EN010007 Wylfa Newydd Nuclear Power Station

Welsh Government (IP Number: 20011597) Deadline 7 Submission – 14 March 2019

**Figure 2-2 Indicative Construction Workforce Profile**

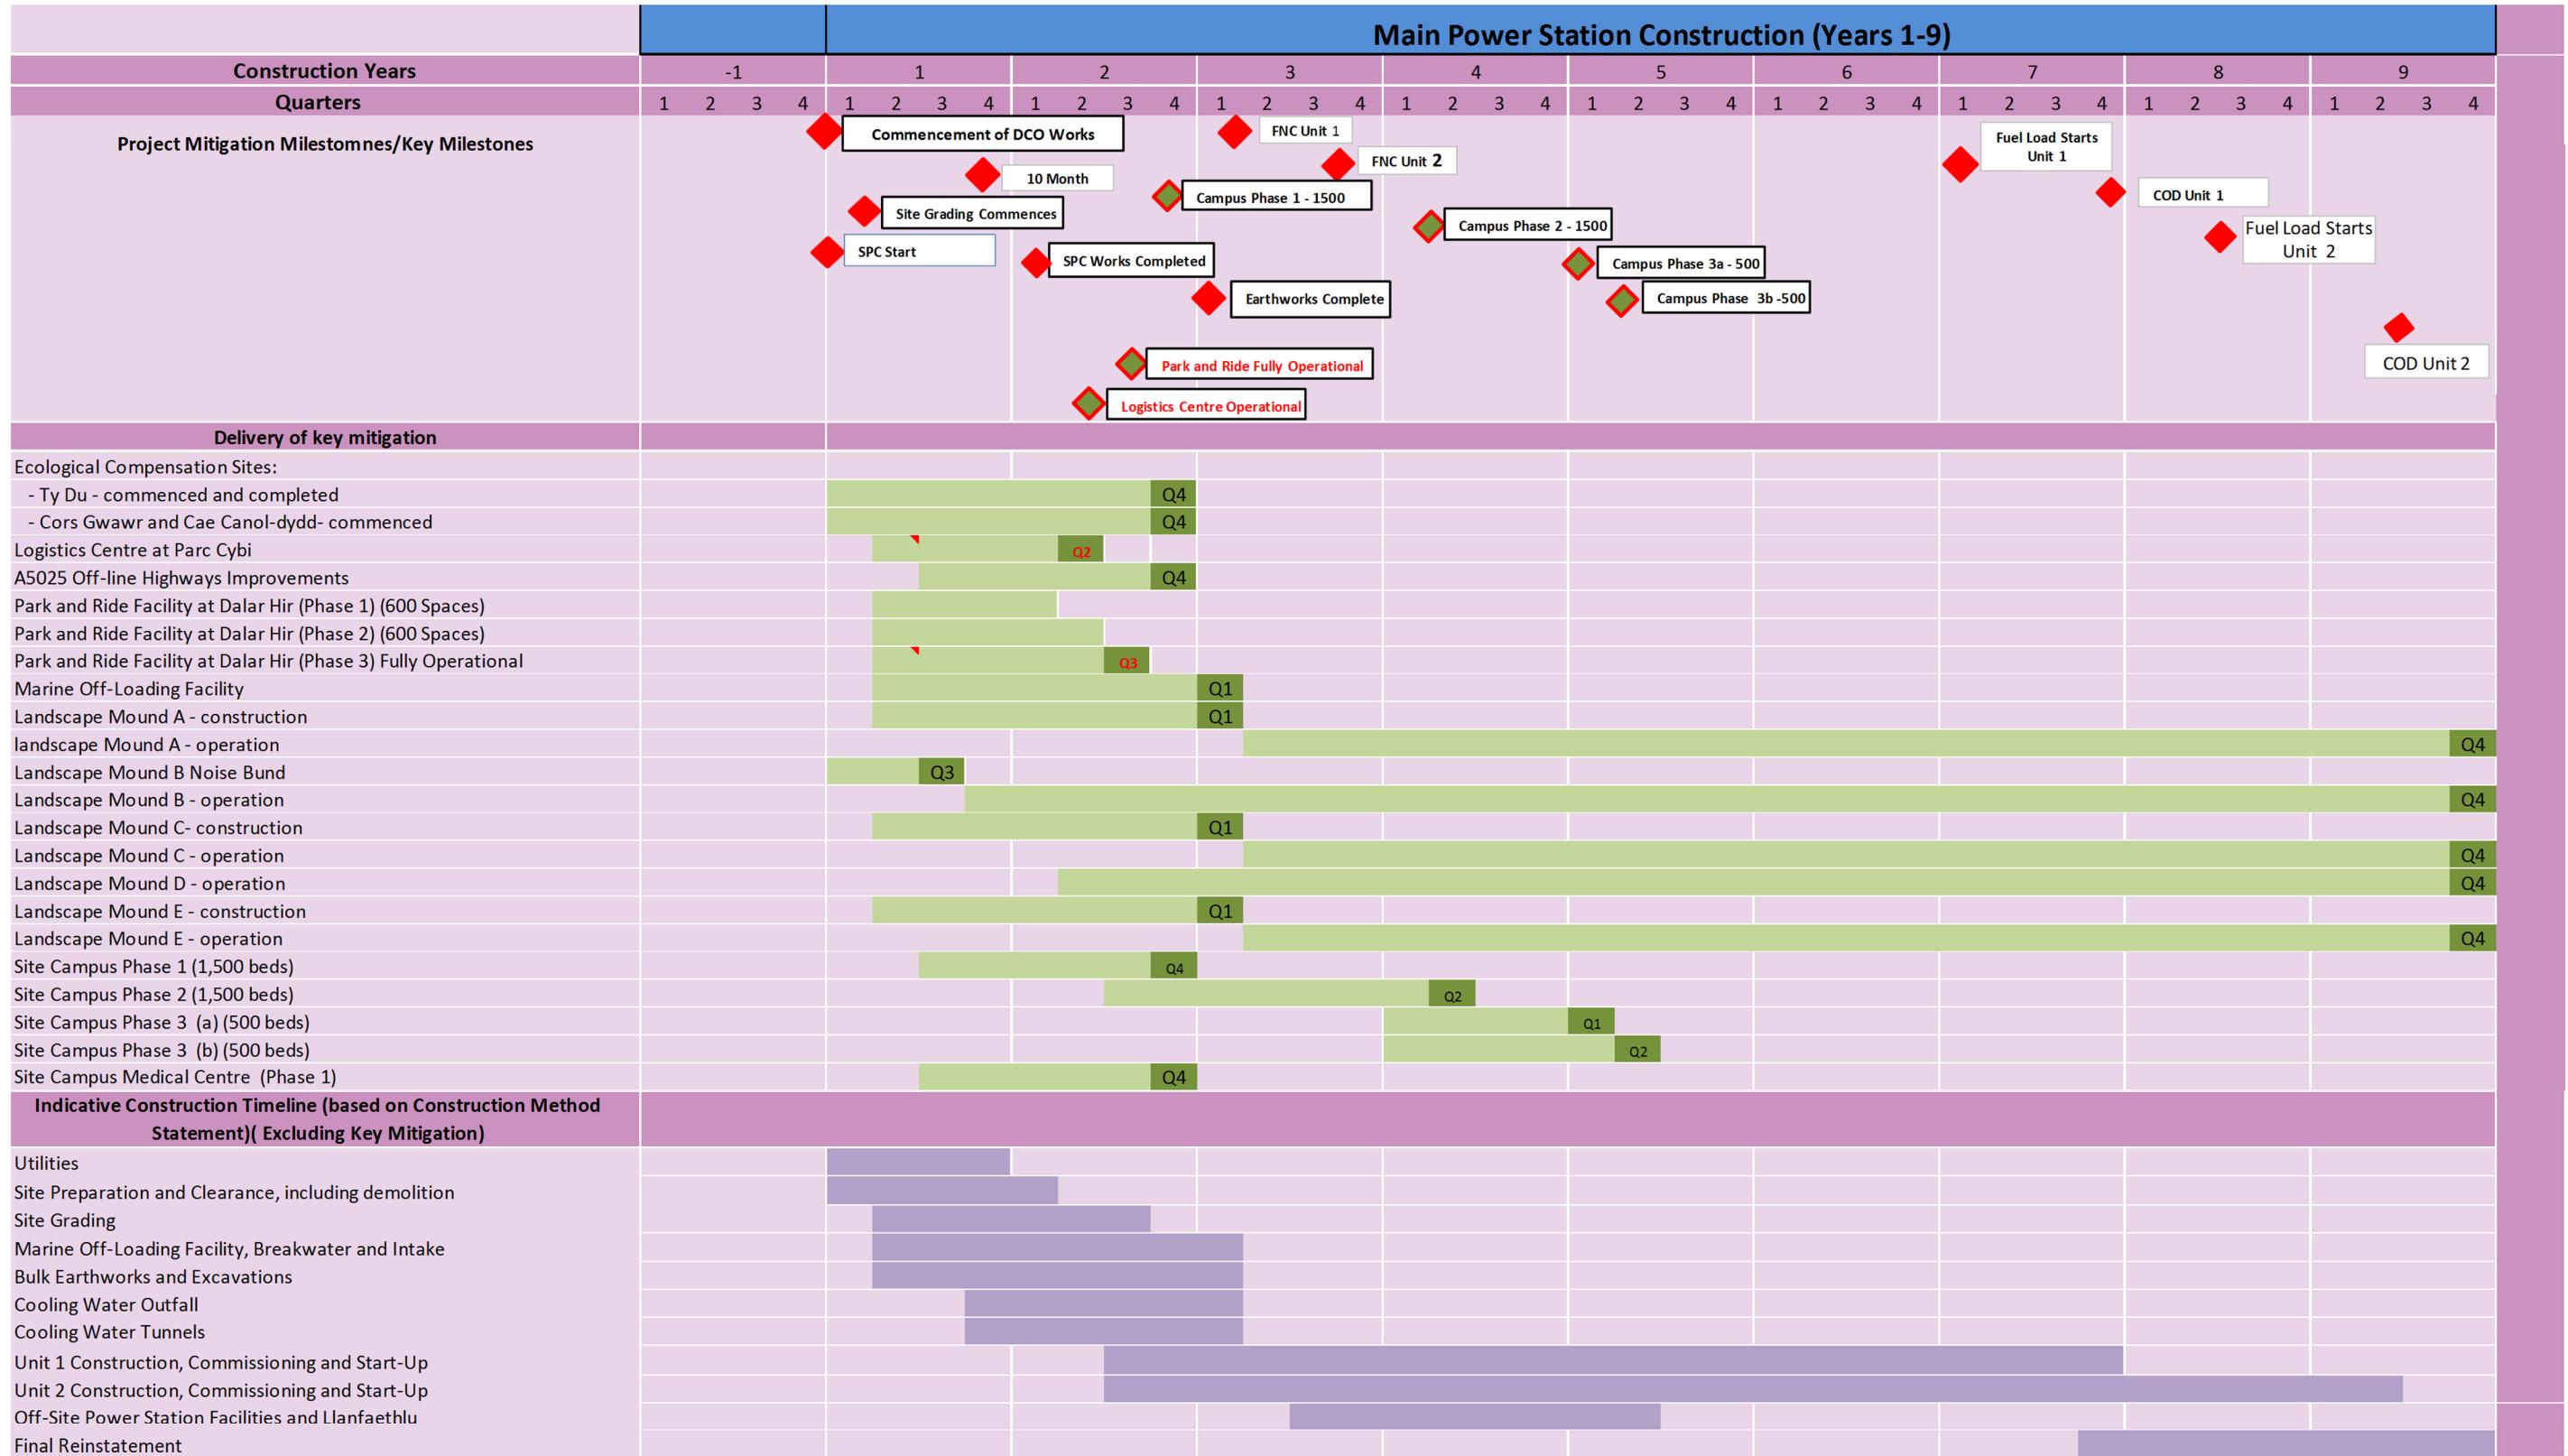
1.1. The Site Campus has been identified by Horizon as 'Key Mitigation'. Crucially, the provision of 4,000 bedspaces will provide for 44.4% of the overall worker numbers assessed in the Environmental Statement, and in respect of Non Home Based workers will account for 57% of accommodation. To highlight, as a ratio this broadly means that for every 1,000 Non Home Based workers, there is a need to provide approximately 570 bedspaces on the Site Campus. Welsh Government has provided previous representations (REP2-367) regarding the need for early delivery of the phases of the Site Campus and how the current proposed phasing is not in line with the potential demand from the build-up of the workforce.

2.1. Welsh Government has previously raised concerns [Appendix B of REP6-062] about the proposed triggers for delivering the phases of Temporary Worker Accommodation (TWA), and the proposed reliance that 50% of the bedspaces would be provided in the final phase. In particular, that the current proposed triggers for phasing could result in Horizon working outside of the parameters assessed in the Environmental Statement, which would be contrary to paragraph 9.1.6 of the Workforce Accommodation Strategy (APP-412), which states:

- 2.2. Page 64 of the Construction Method Statement (CMS) (Revision 2.0, REP5-019) identifies that Phase 1 of the Site Campus (1,000 bedspaces) will be complete at Time Slice 3 (Site Grading). As per the figure above, this would imply Q1 Y2, and not Q4 Y4 as previously stated by Horizon, and that the total campus (page 66 of the CMS) would be complete at Time Slice 5 (Q4 Y2). Therefore, it would appear from Horizon's own evidence that it is possible to deliver the site campus at an earlier date.
- 2.3. Welsh Government suggest that the Phasing Strategy is amended to align with the delivery timescale in the CMS. It is also considered that the Phasing Strategy should be renamed as the Key Mitigation Delivery Strategy, so that it is clear what it relates to.

- 4.1. In light of the information in the CMS, the controls around noisy activity, the role the WAMS could play to ensure that in the early years of construction occupation of the first phase of the TWA was limited to workers on day shifts, the Welsh Government would suggest that the Phasing Strategy is amended as follows:

Phase	Number of Bedspaces	Trigger
1	1,000	Quarter 1 Year 2, or 2,000 Non Home Based Workers (whichever comes first) – restricted to Day Shift Workers
2	500	Quarter 1 Year 3, or 3,000 Non Home Based Workers (whichever comes first)
3	1,500	Quarter 2 Year 4, or 4,200 Non Home Based Workers (whichever comes first)
4	1,000	Quarter 4, Year 5, or 6,000 Non Home Based Workers (whichever comes first)
